# Rezoning Transportation Analysis

Petition Number: 2022-199

**From:** Jake Carpenter, PE  
Jacob.carpenter@charlottenc.gov  
980-221-5675

Date	Description
4-27-23	First Review (TM)
05-24-23	Second Review (TM)
07-26-23	Third Review (TM)

**SCHEMATIC
 SITE PLAN**

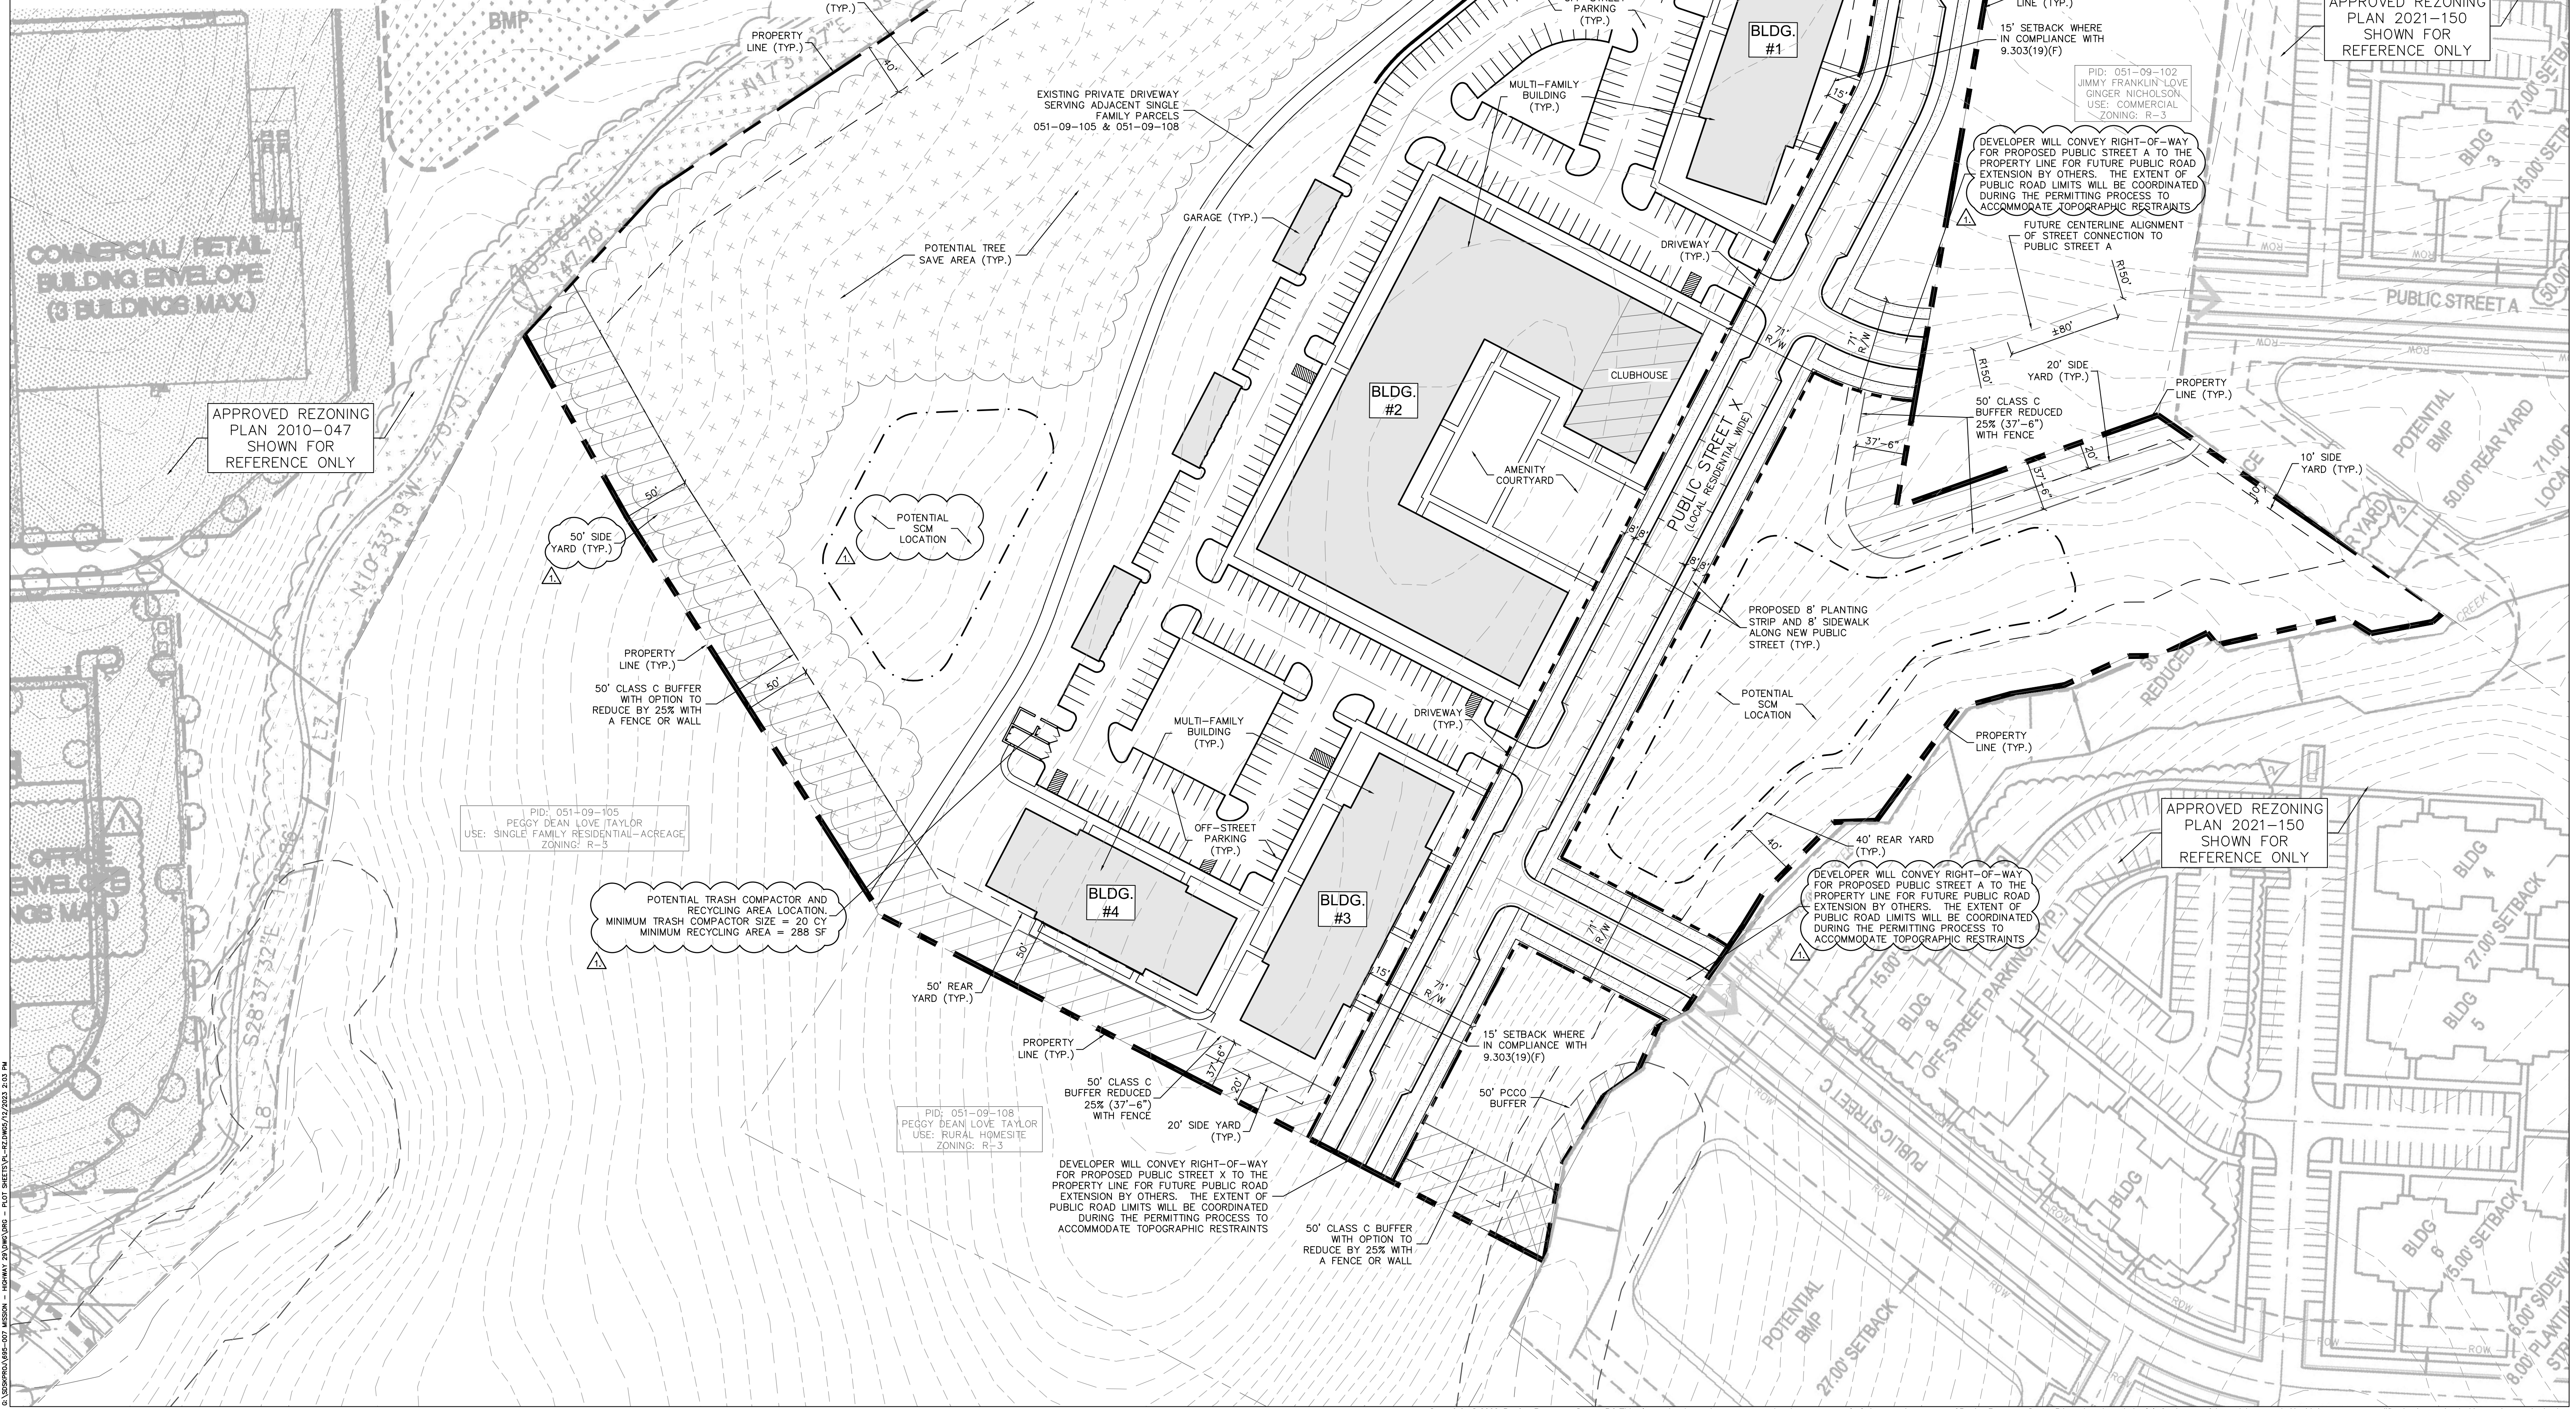
### 1. Curbline:

- a. ~~US 29 Highway:~~ Location of curb and gutter to be moved to 44 feet from roadway centerline to accommodate the Charlotte Streets Map with a roadway typical section of 6+ Boulevard, Shared Use Path.

**NOTE:** Additional distance from center line to back of curb may be required in locations where a median is present or around intersections and interchanges. Add a conditional note that the final location of the curb line is to be determined during the permitting process.

Label and dimension the curb and gutter from the centerline for each road on the site plan.

3. **NEW COMMENT (07-28-23):** Revise site plan and conditional notes to commit to relocate proposed site access to the west along US 29 and to coordinate site access location and median extension limits with NCDOT. Site plan shall label and dimension the change along with adding conditional notes committing to the coordinating with NCDOT.

- ~~8. Revise site plan and conditional note(s) to commit to coordinating with CDOT on street and pedestrian lighting during permitting.~~
9. **Outstanding comment from 04-27-23:** Add a conditional note specifying “All transportation improvements will be approved and constructed before the site’s first building certificate of occupancy is issued. The petitioner may phase transportation improvements if said improvements and phasing are explicitly described in site plan notes.”
